DRB CASE ACTION LOG

DRB Application No.: 02DRB-01870 (P&F)	Project # 1002381
Project Name: MRGCD MAP 41	EPC Application No.:
Agent: Surveys Southwest Ltd.	Phone No.: 9980303

DEVELOPMENT REVIEW BOARD TRANSPORTATION DEVELOPMENT Standard Comment Sheet

Subject: MRGCD Map 41

**PLAT OF  
TRACTS A-1 & B-1  
LANDS OF JOE E. BACA AND AURORA BACA  
IN PROJECTED SECTION 29, T10N, R3E, N.M.P.M.  
TOWN OF ATRISCO GRANT  
CITY OF ALBUQUERQUE  
BERNALILLO COUNTY, NEW MEXICO  
NOVEMBER, 2002**

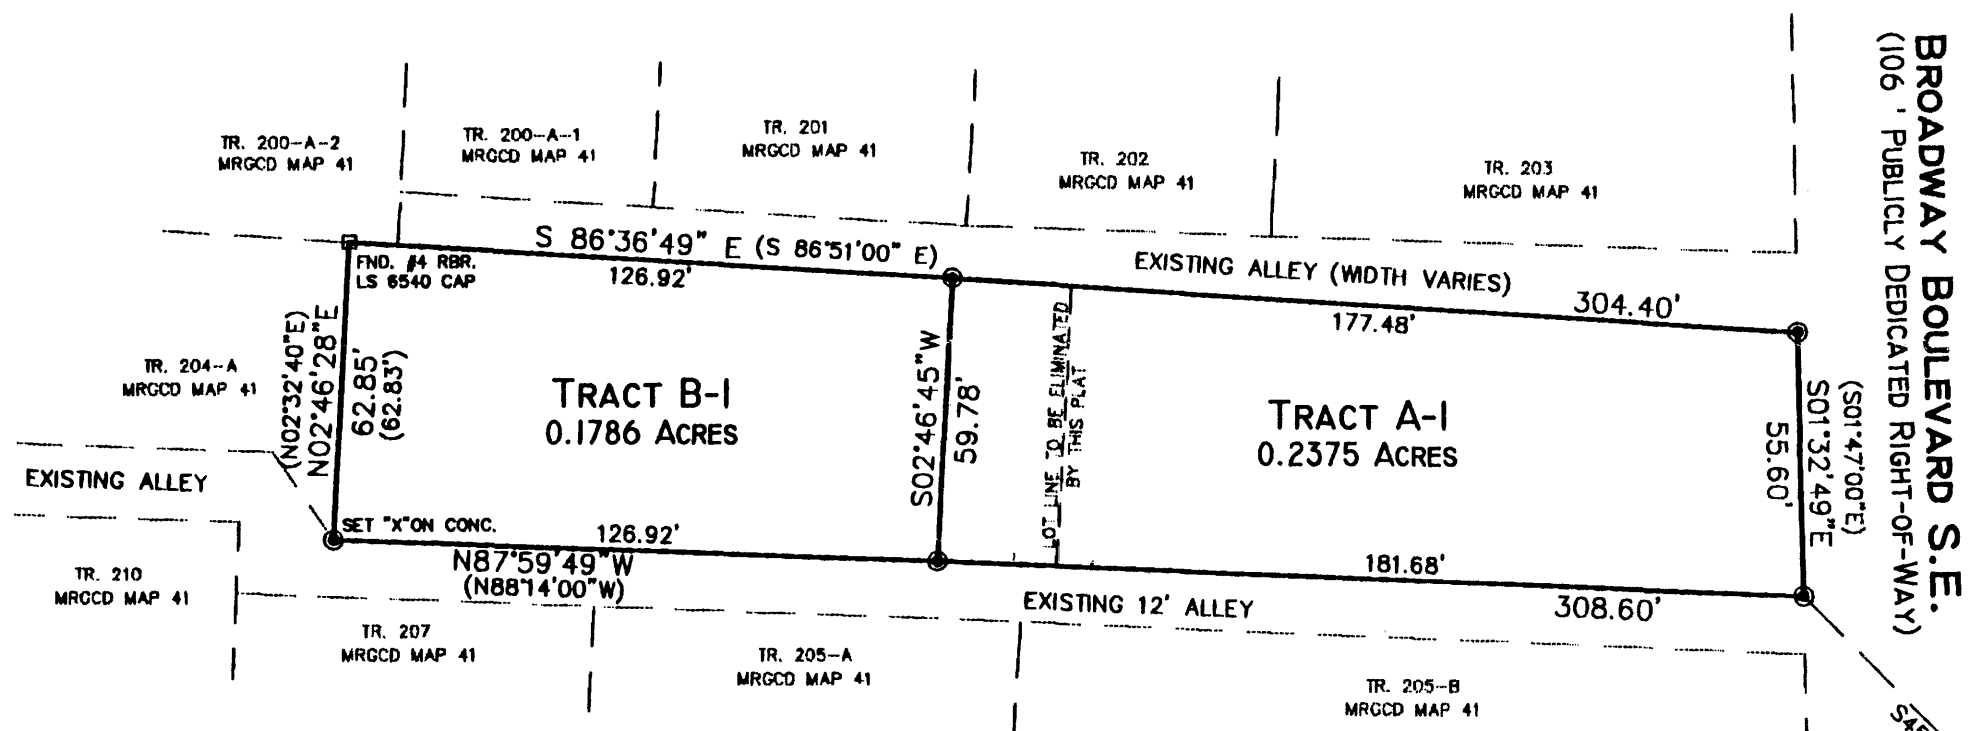
- 10' from face of curb on BROADWAY
- Alley dedication
-
-

- Need evidence of two separate water/sewer/refuse accounts.
-
-

No.	Comment
1	Need to dedicate 10 ft from the face of the curb on Broadway.

Be sure to fill in the Project & Application #s on the final plat.
